Recommendation Report for Planning Permission for Works or Extension to a Dwelling

REF NO: BR/171/25/HH

LOCATION: 17 Annandale Avenue
Bognor Regis
PO21 2ES

PROPOSAL: Single storey rear extension and single storey porch extension.

Proposed Floor Plans, Section
and Elevations

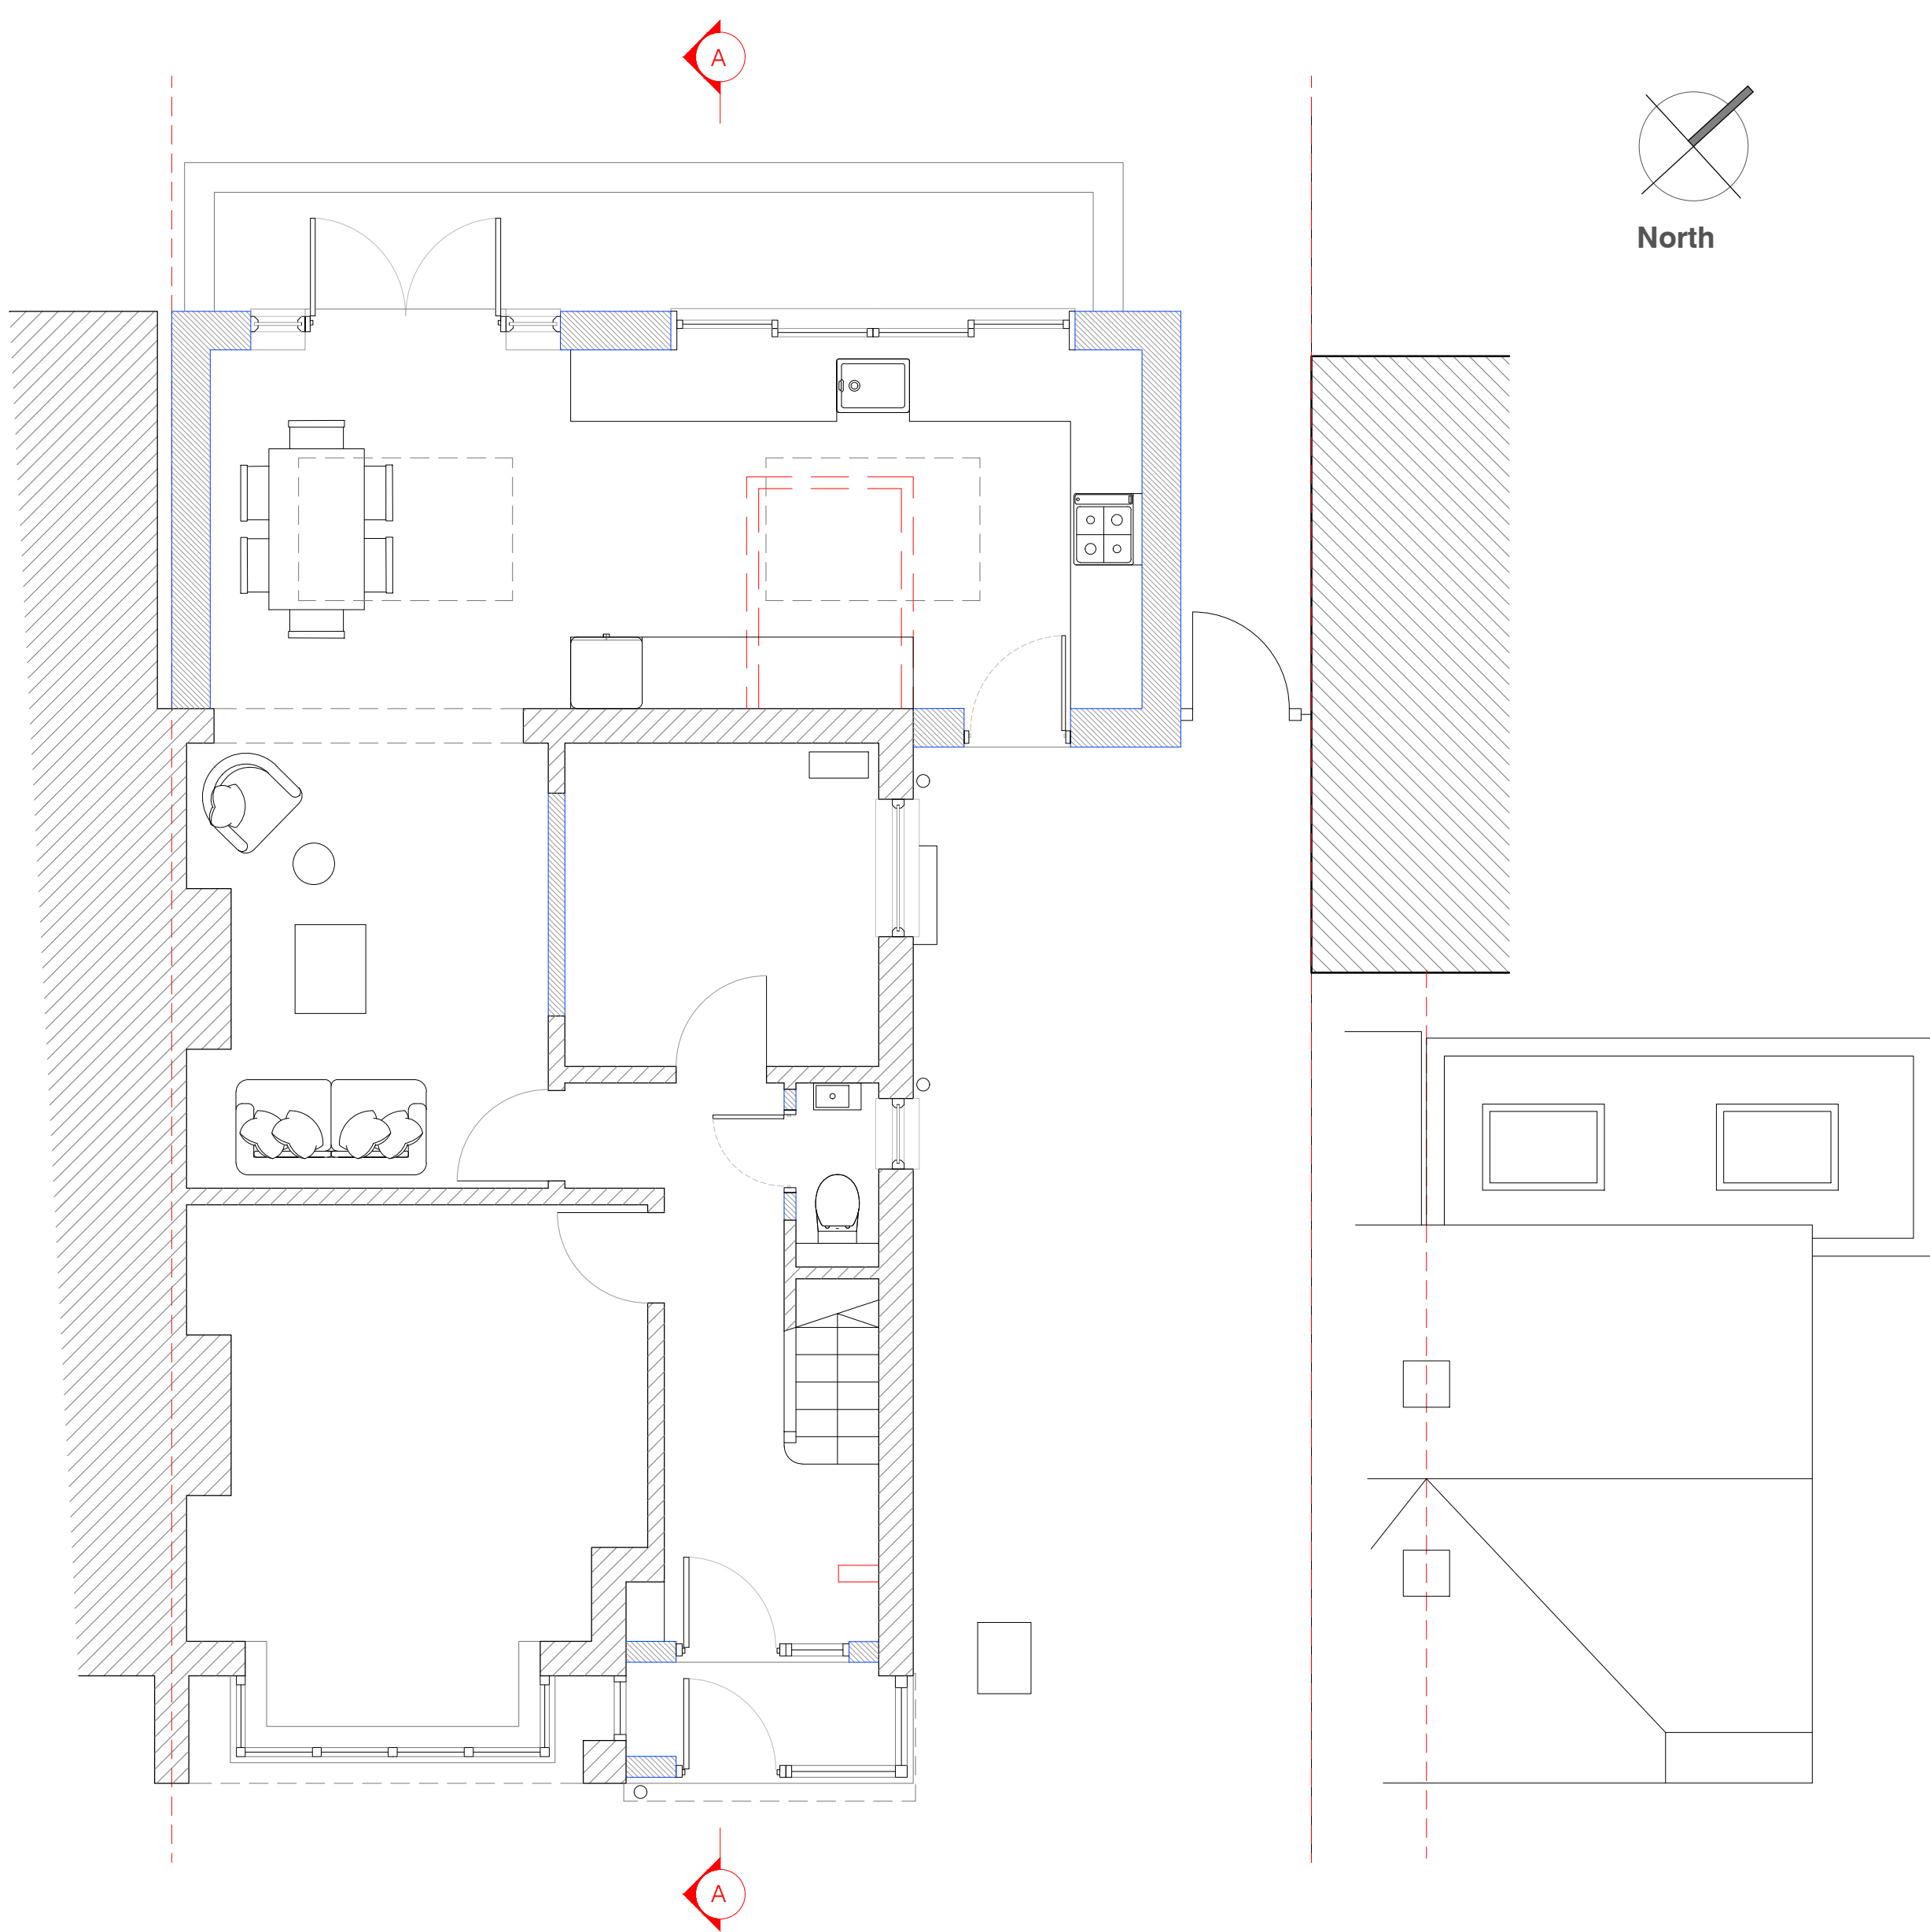
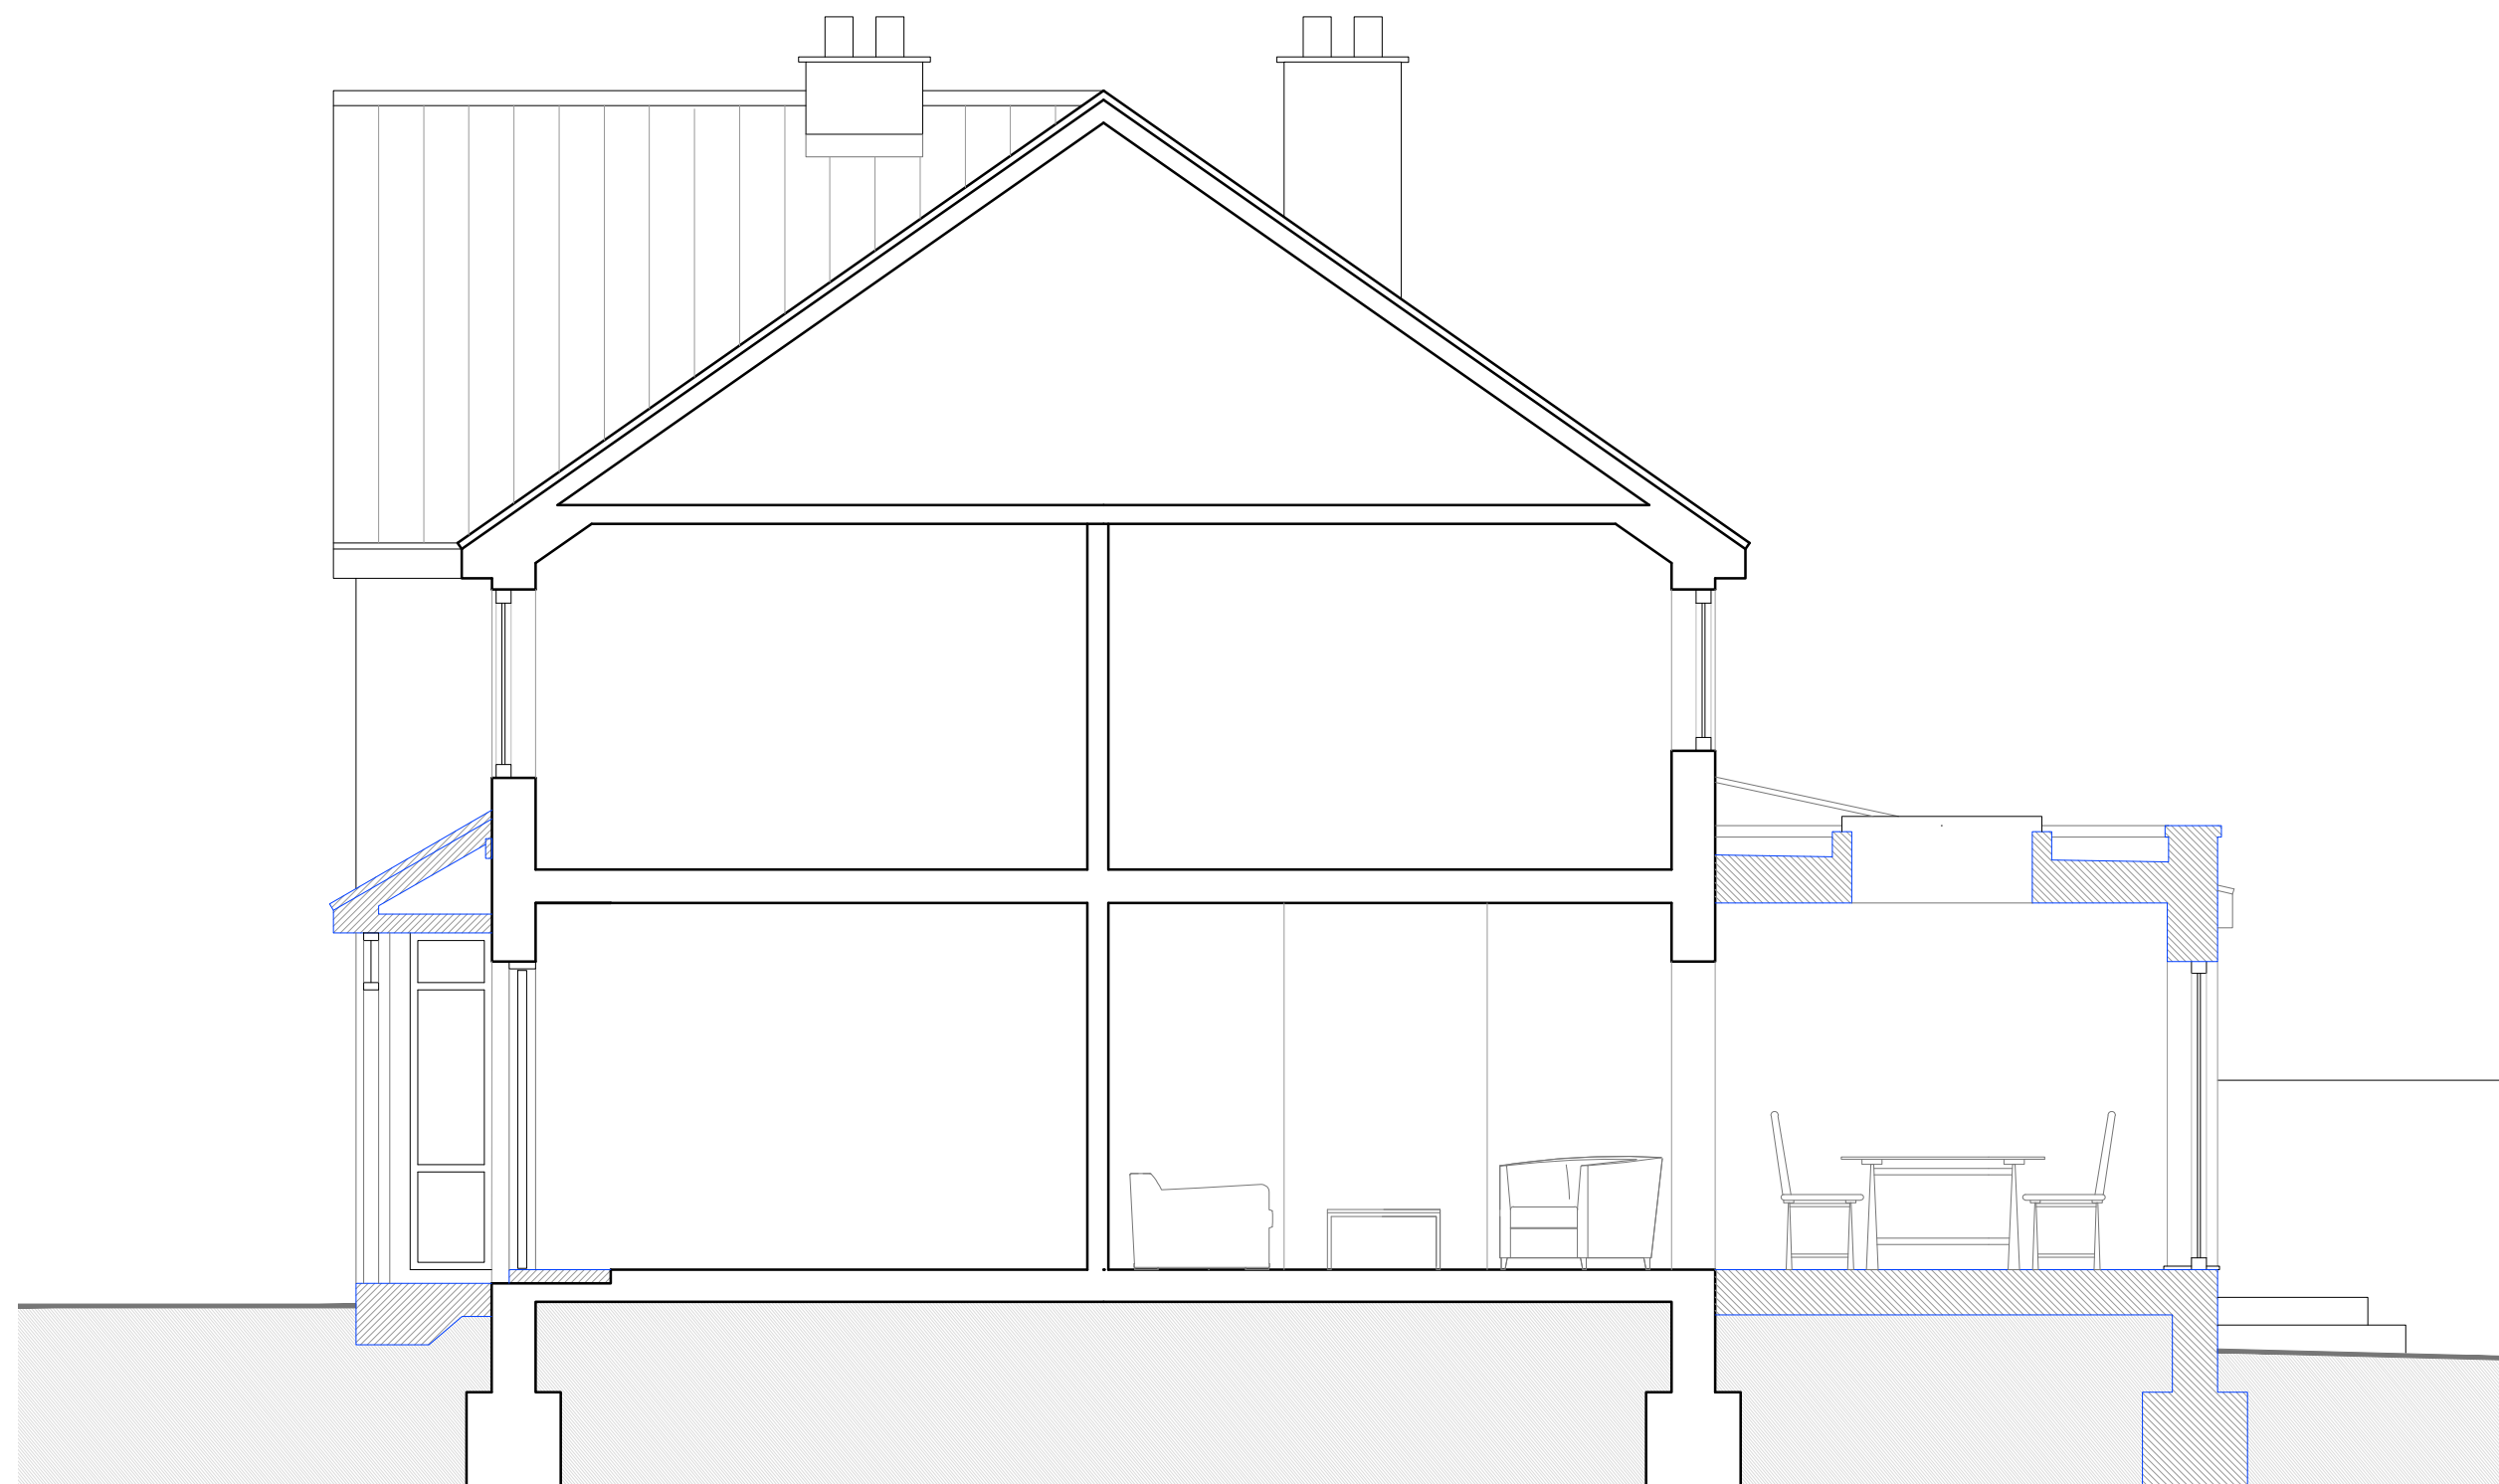
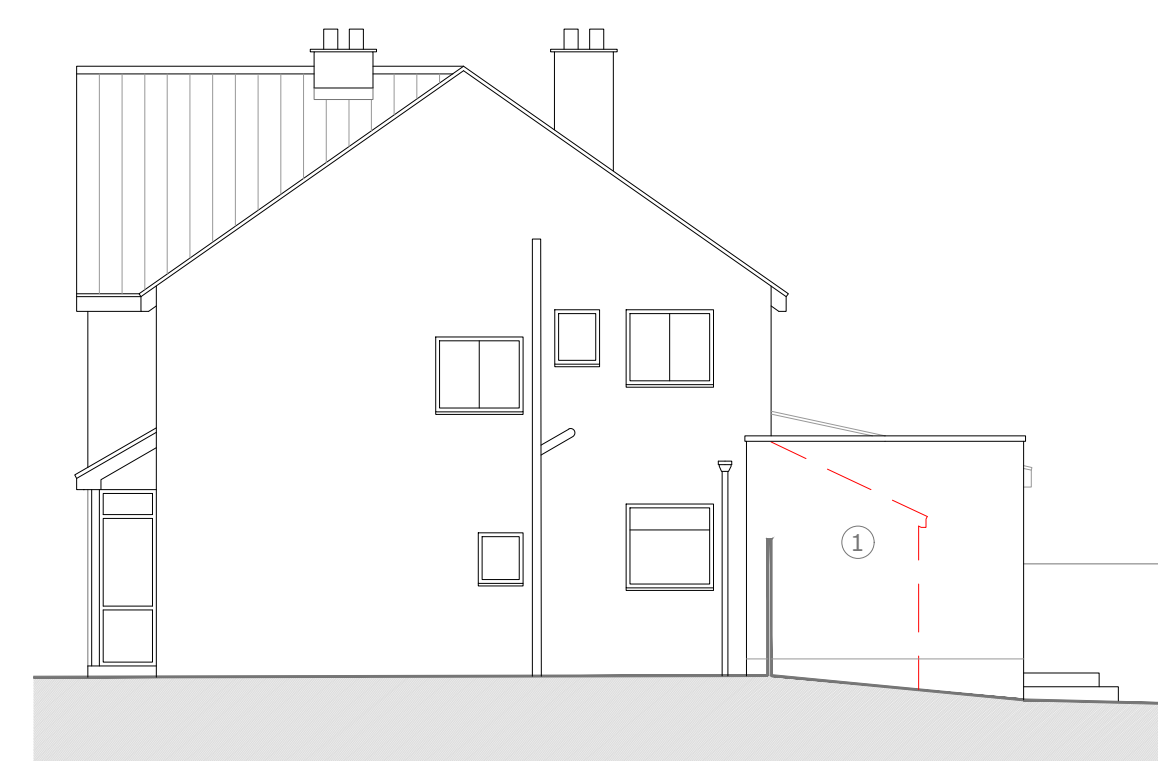
The proposed single storey porch extension would have an approximate width of 2.5m and an approximate increase in depth from 1m to 1.8m. The existing porch is incorporated within the host dwelling and the proposed porch extension would alter the visual appear to a pitched roof and have a maximum height of 3.3m and an eaves height of 2.5m.

The combined depth of the existing and proposed porch would exceed the Arun Design Guide (ADG) depth of 1.5m and it is noted that it would extend forward from the host dwelling. However, the proposed extension would provide a slightly larger footprint, responding sensitively to the bay window serving the front amenity of the host dwelling and therefore would not disrupt the building line or street scene.

Fenestration to the front (south) elevation would be a fully glazed enclosed porch and would be finished with rendered masonry and roof tiles to match the host dwelling. Given the existing variation within the street scene of Annandale Avenue, the proposed porch would not result in harm to the character of the street scene, in accordance with policy D DM1 of the Arun Local Plan (ALP).

The proposed single storey rear extension would have an approximate width of 8.4m and an approximate depth of 3.3m beyond the existing rear elevation of the host dwelling. The proposed rear extension would project beyond the northern elevation with a small wrap around to the eastern flank of the host dwelling. The proposed single storey rear extension would have a flat roof with an approximate maximum height of 3.5m, containing two sunken rooflights. The rooflights would be in accordance with Part M of the Arun Design Guide (ADG) and would maintain the privacy of the neighbouring properties.

The proposed single storey rear extension would be finished with rendered masonry to match the host dwelling. Fenestration to the rear (north) elevation would include patio doors and a window. Fenestration to the southern elevation would be a single door.

The proposed single storey porch extension would be set in approximately 3.2m from the neighbouring side (eastern) boundary and set back approximately 3.85m from the front (southern) boundary. The proposed single storey porch extension would not project beyond the neighbouring dwellings front projection and would not result in overbearing or overshadowing to the neighbouring dwellings.

The proposed single storey rear extension would abut the neighbouring dwelling's (west) boundary and would be set back approximately 11.8m from the rear (northern) boundary and set in approximately 1.1m from the side (eastern) boundary.

The western flank of the proposed rear extension extends approximately 3.3m in depth and would

remain subservient to the host dwelling. The proposed extension would extend in line with the existing rear elevations of neighbouring properties and as such, the proposed rear extension would not result in overbearing or overshadowing impacts to neighbouring properties. Given the spacing maintained between the rear extension and the rear boundary to the north, the proposed rear extension would not result in overbearing or overshadowing impacts to neighbouring properties to the north.

The proposed fenestration within the rear elevation would have an outlook across the rear amenity of the host dwelling, and given the spacing maintained between the rear extension and the rear (northern) boundary, the proposed fenestration would not result in overlooking to the neighbouring properties to the north. Concerns raised regarding the rear (northern) boundary separation distance and loss of privacy have been noted. However, within the vicinity there are a number of examples of similar size single storey rear extensions and the proposal would retain a rear garden with a depth of 11.8m from the rear (northern) boundary. Therefore, the proposed single storey rear extension would not result in overlooking to the neighbouring dwellings.
